Application no: H21/1023/00

Description: Erection of 2 x 3 bed detached
bungalows

Location: Adj. 48 Station Road
Tydd Gote
Wisbech

Amendment: Rear fence added, side fences to drop down to 1 metre
high post & rail fence. Brick brochure.

0010001 A2/C

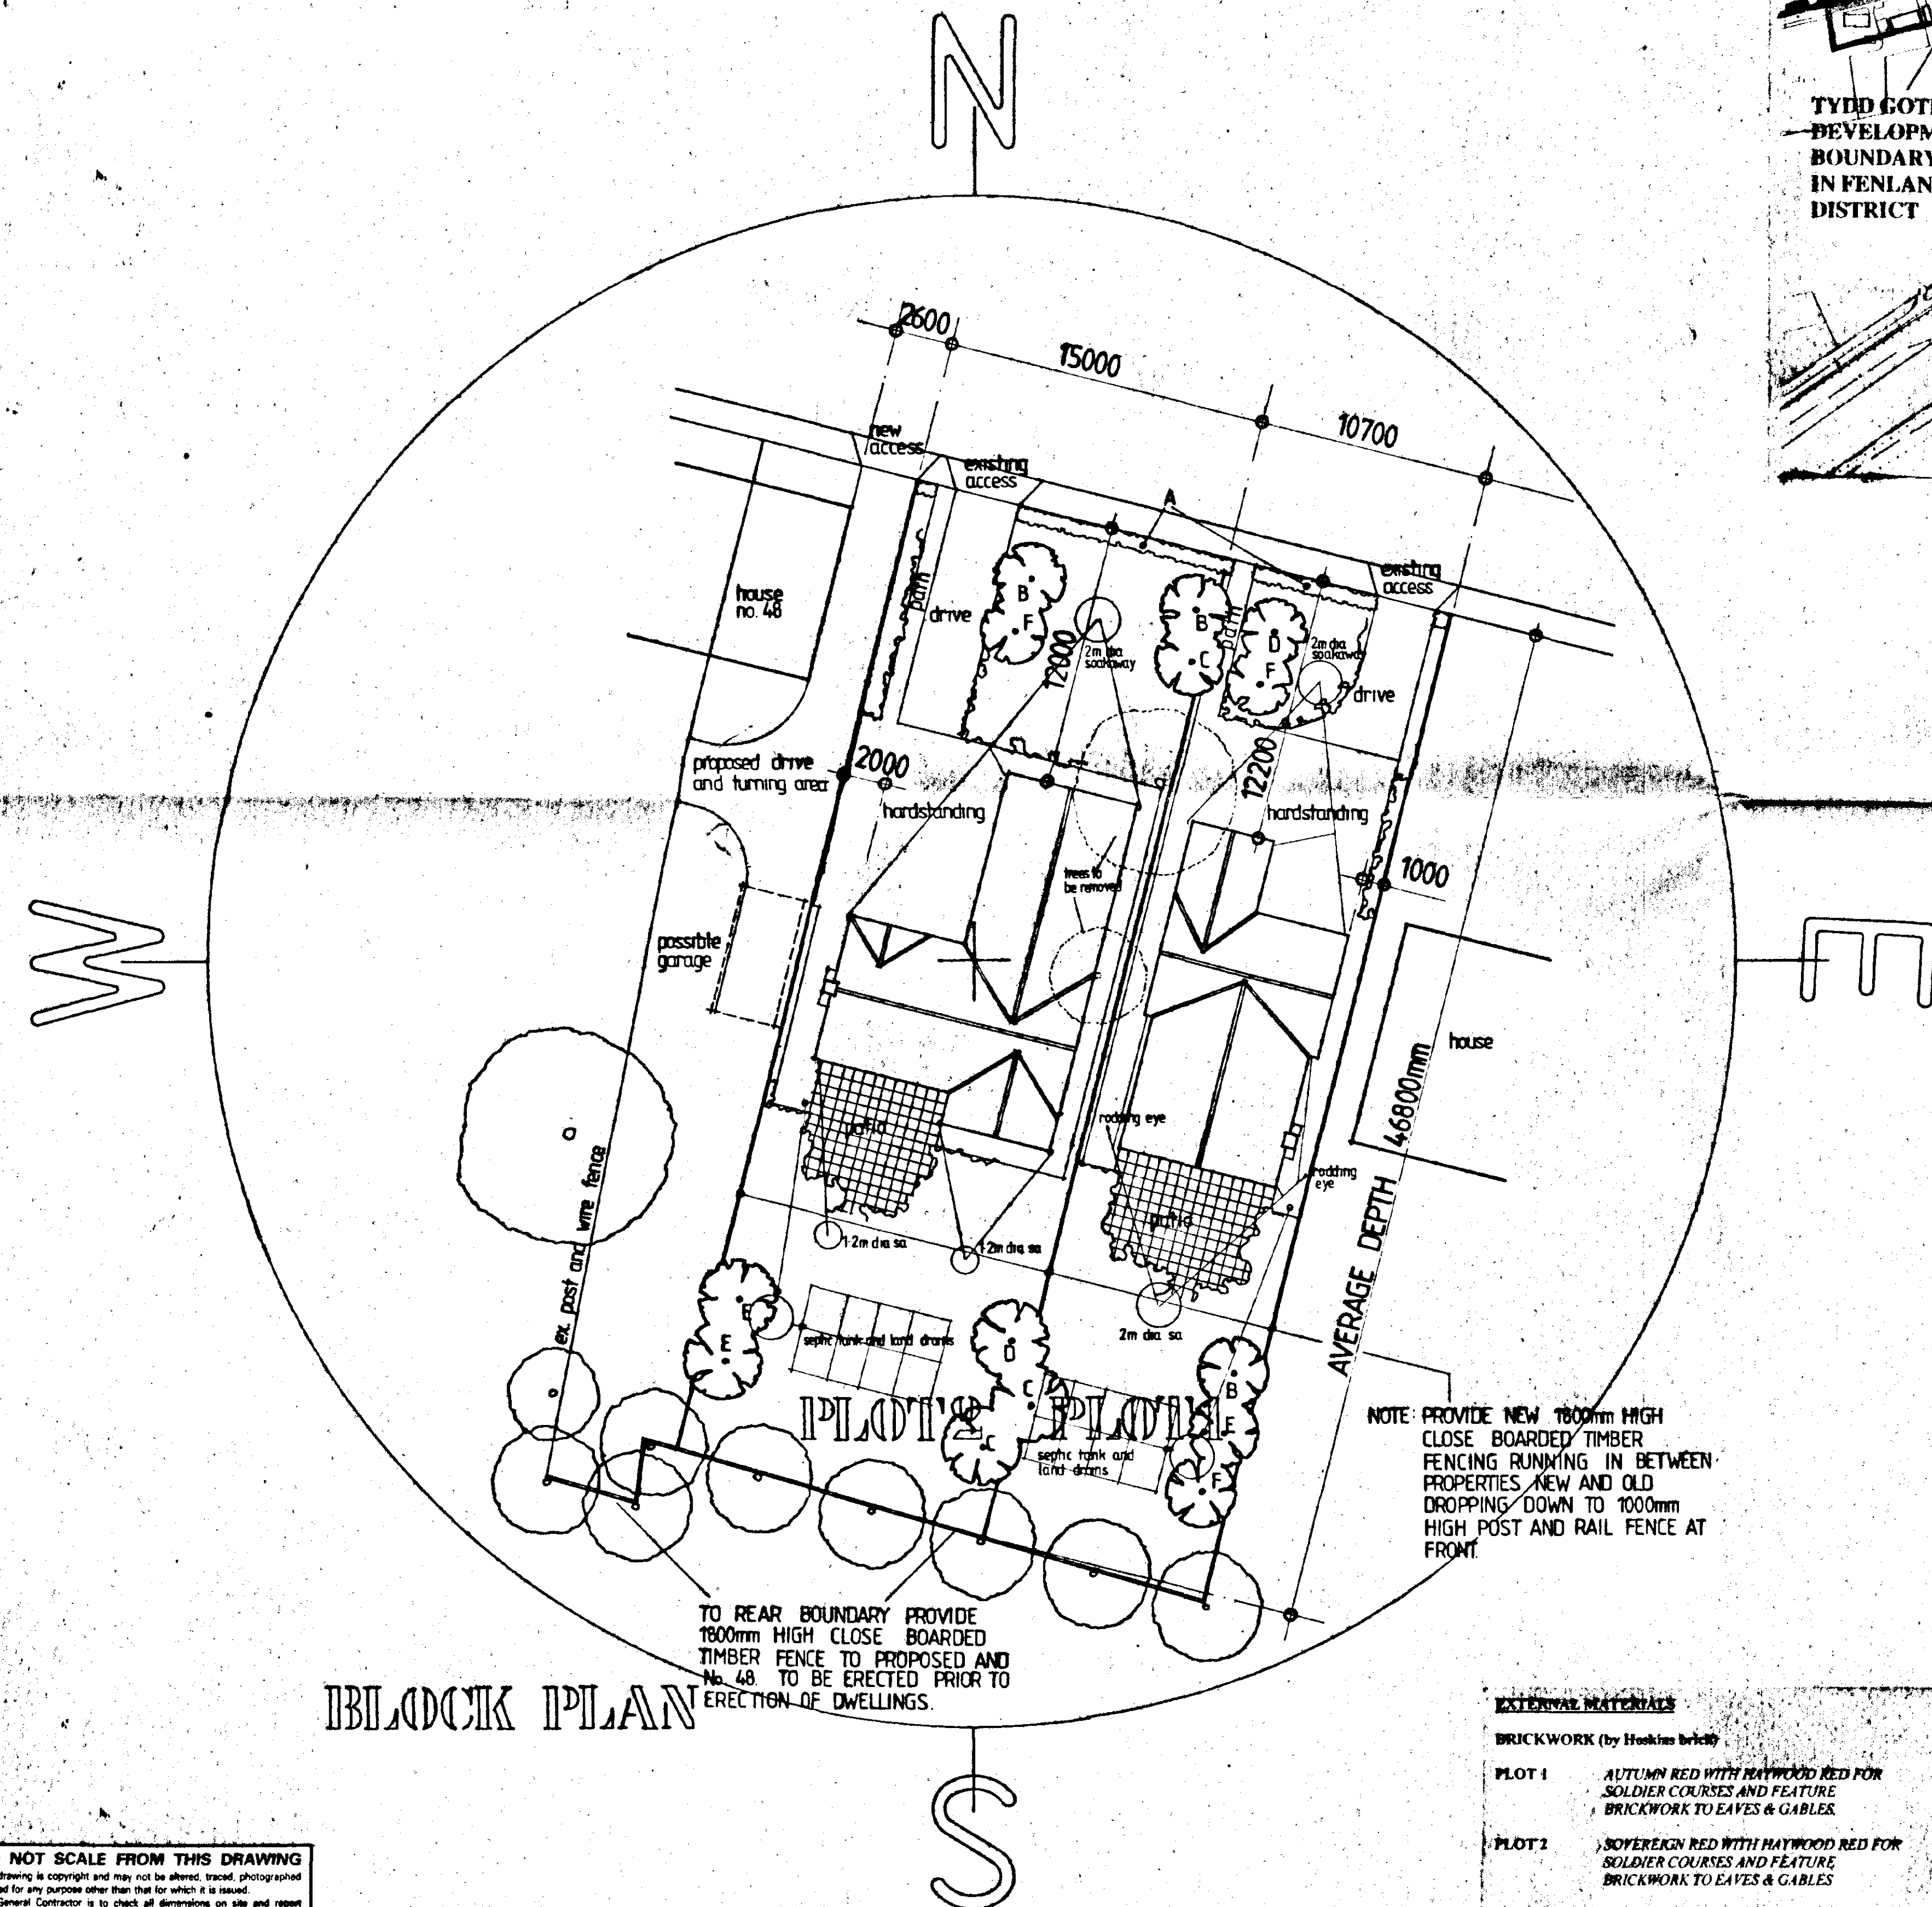
Amendment: Move Plot 2 bungalow back 1.6 metres
Dwg. no. 084/00/01C

Move back Plot 2 Bungalow 1.6m.

BLOCK PLAN

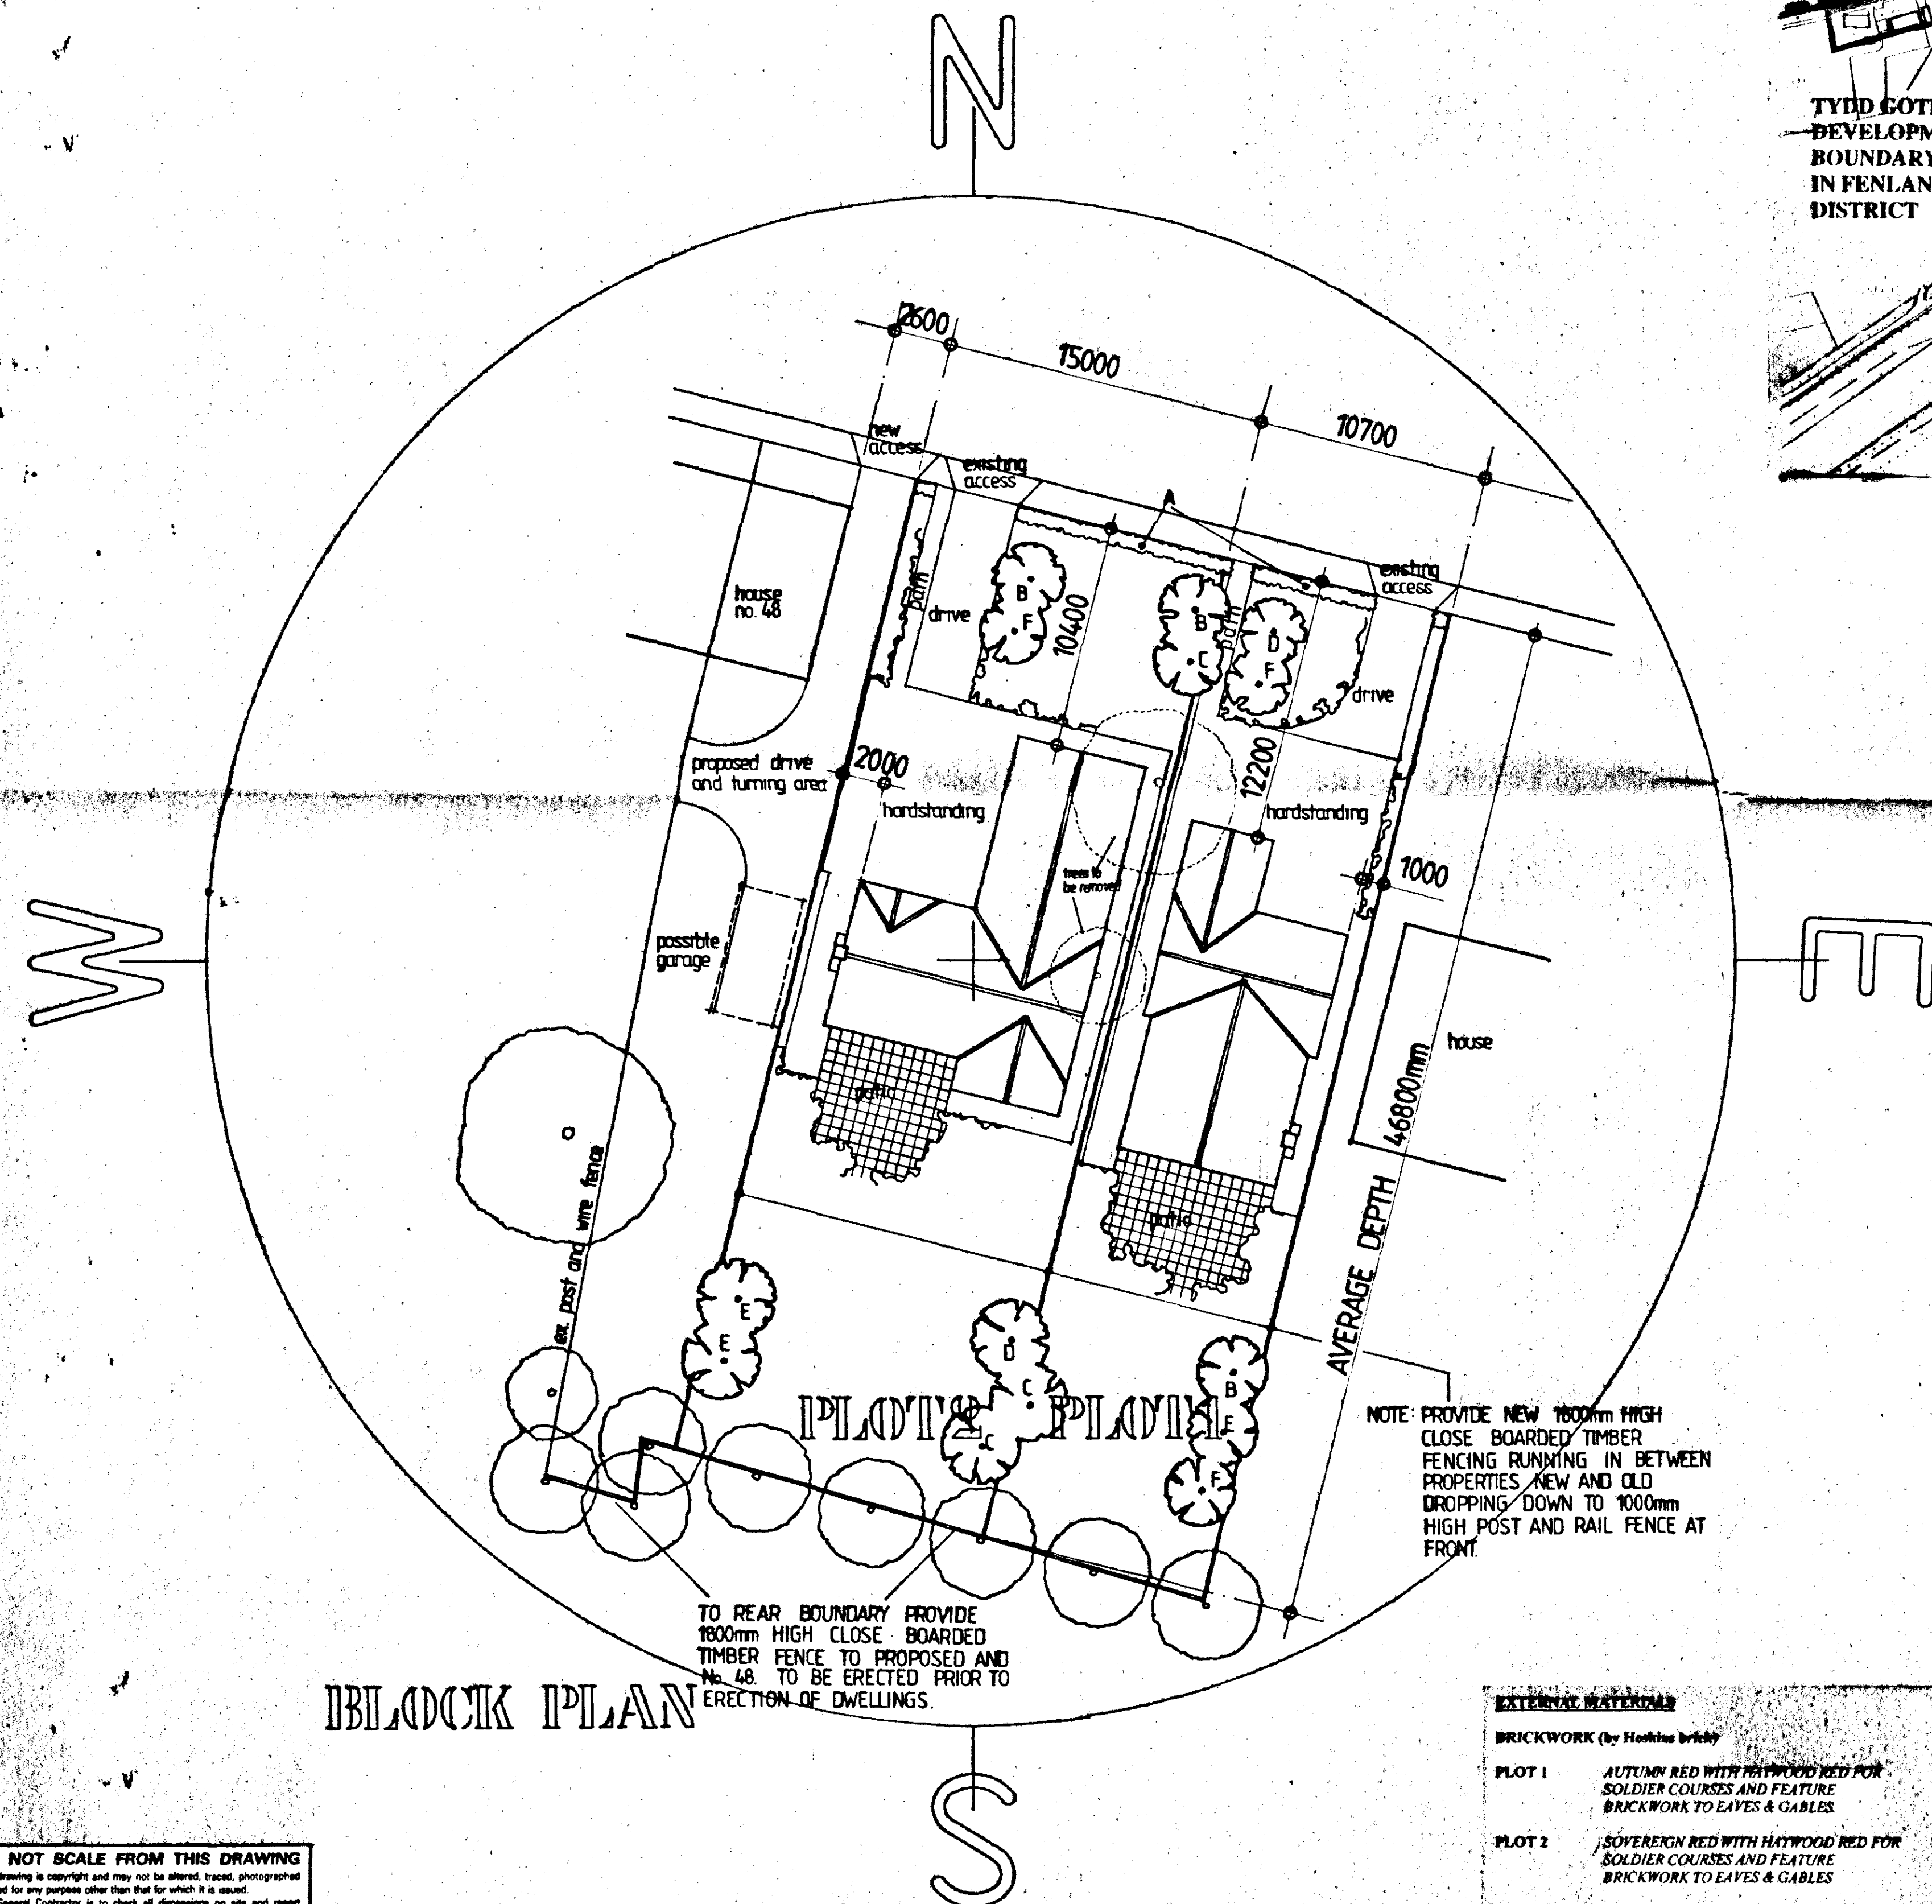
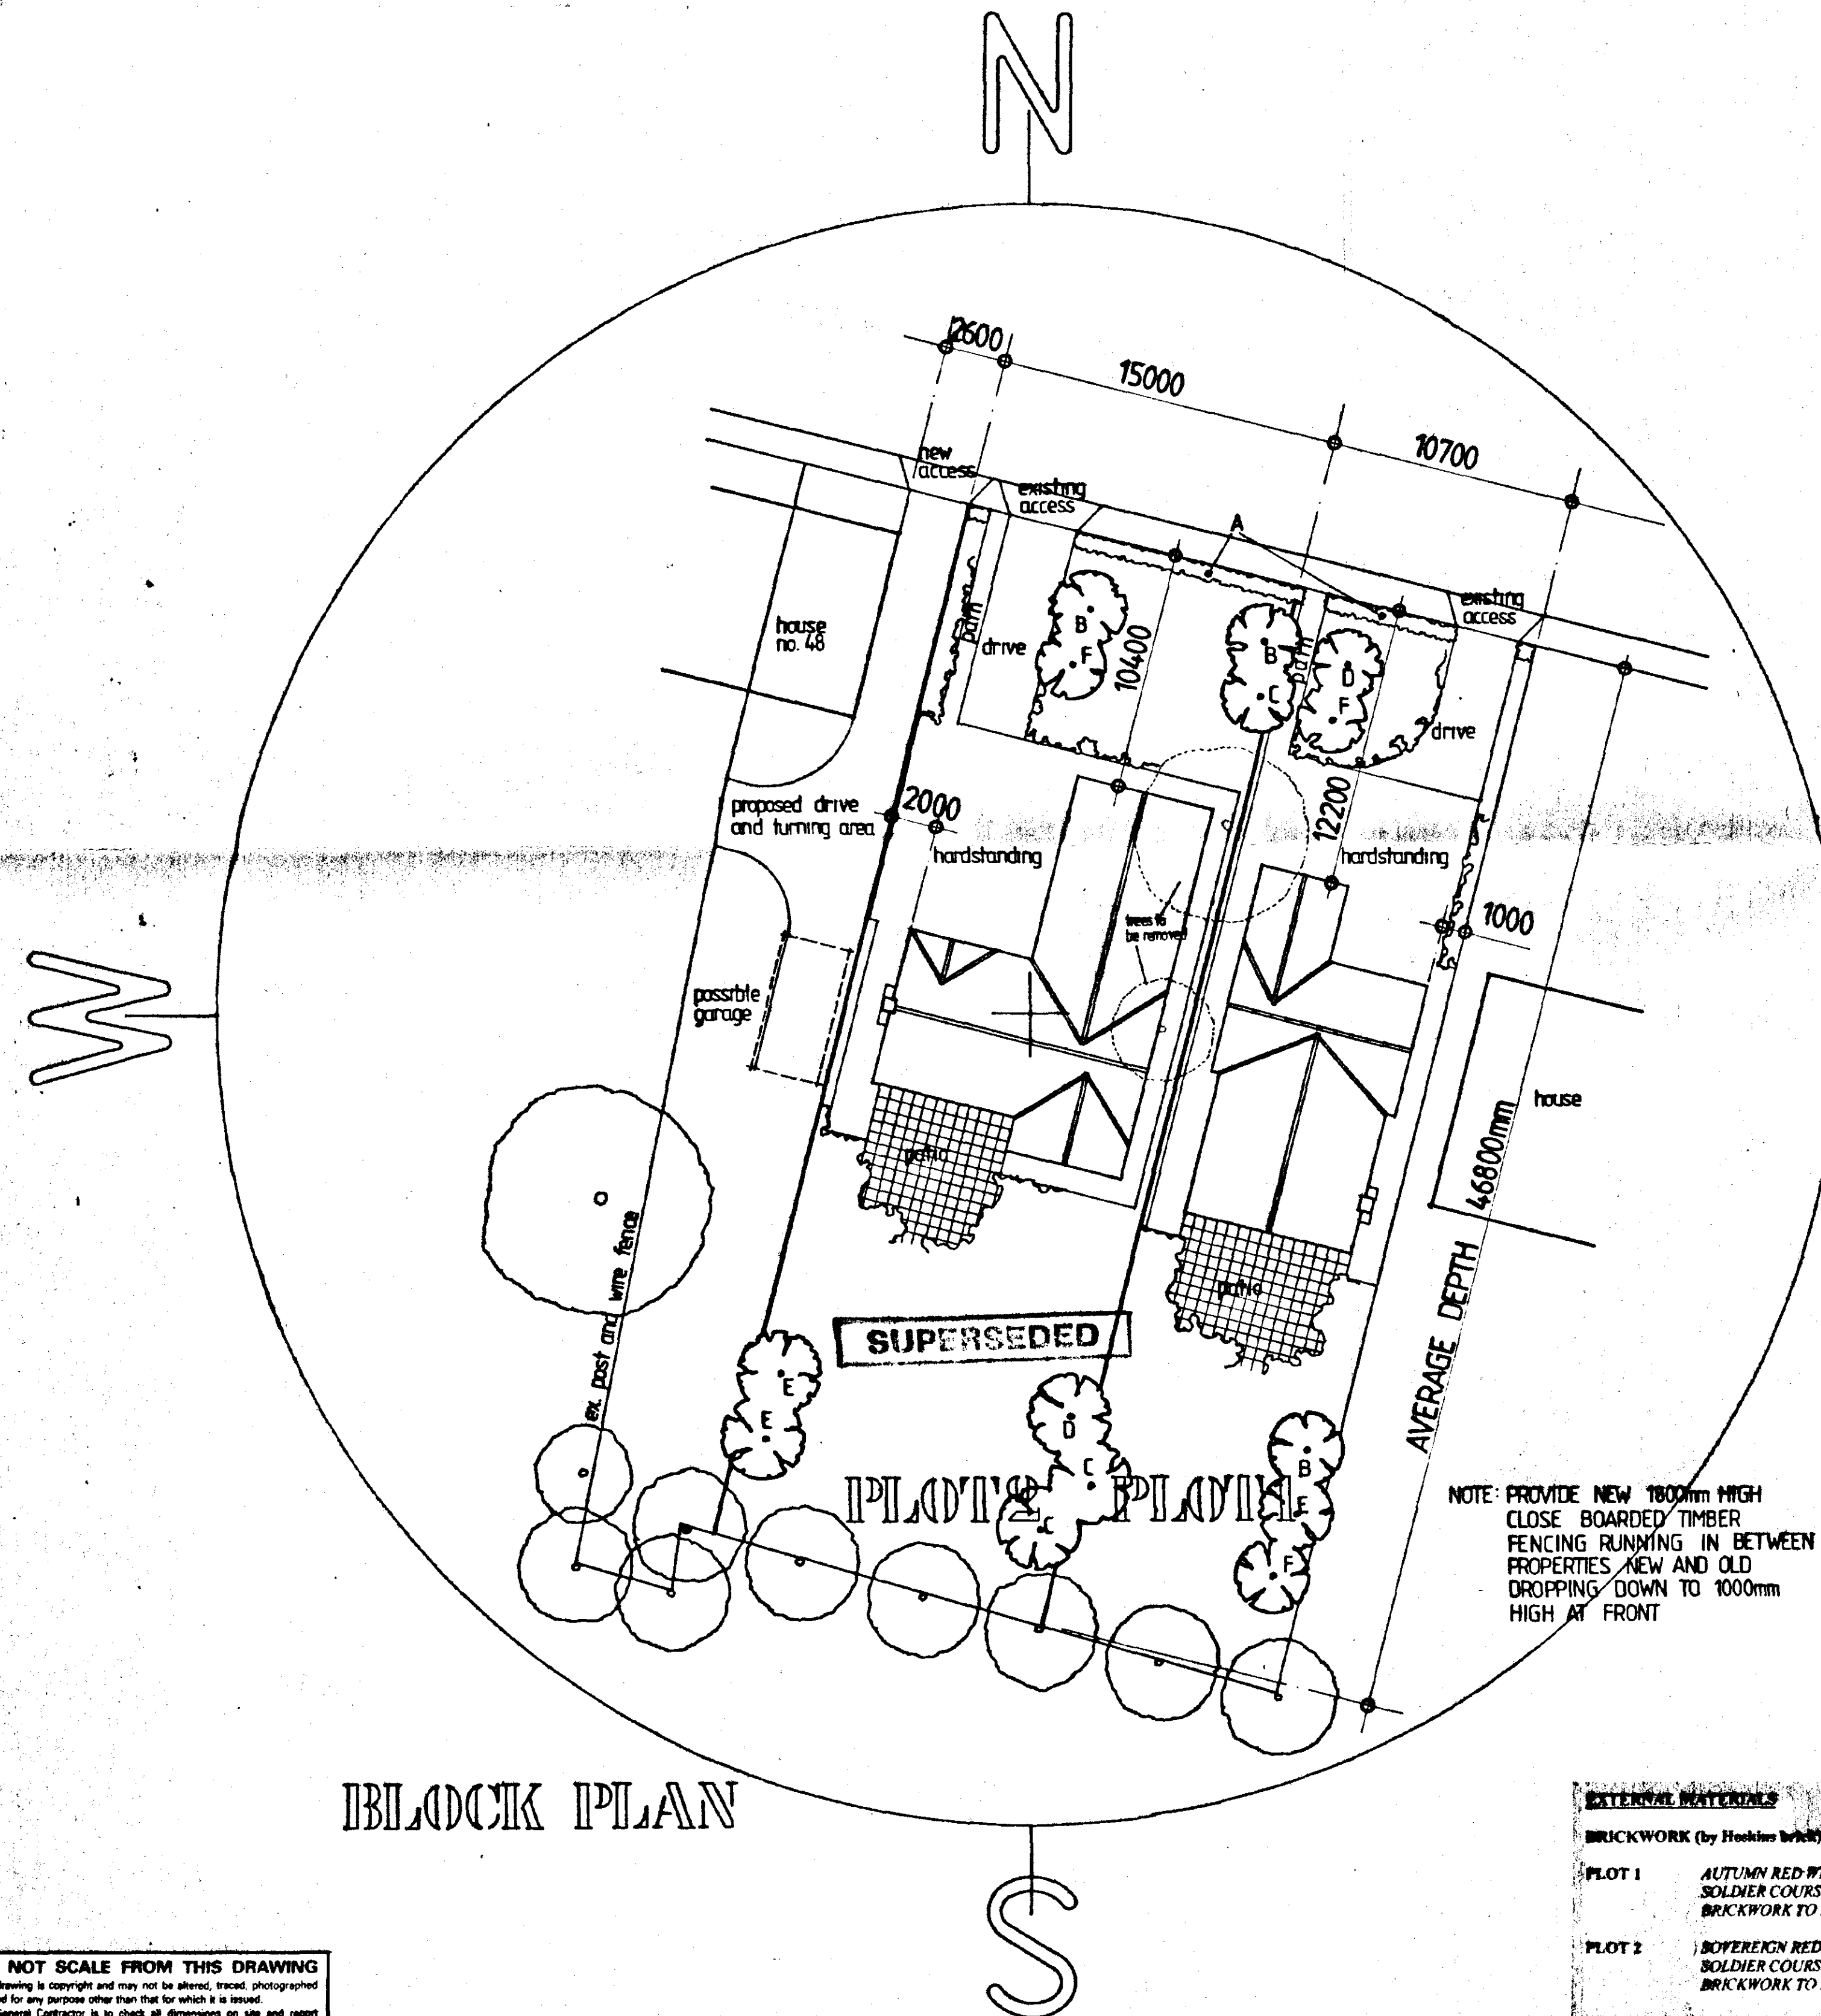
REAR FENCE ADDED TO BE ERECTED
PRIOR TO ERECTION OF DWELLINGS.
SIDE FENCES TO DROP DOWN TO A 1000MM
HIGH POST & RAIL FENCE AT FRONT.
BRICK BOLLARD (DELIVERED BY SEPARATE
SOURCE).
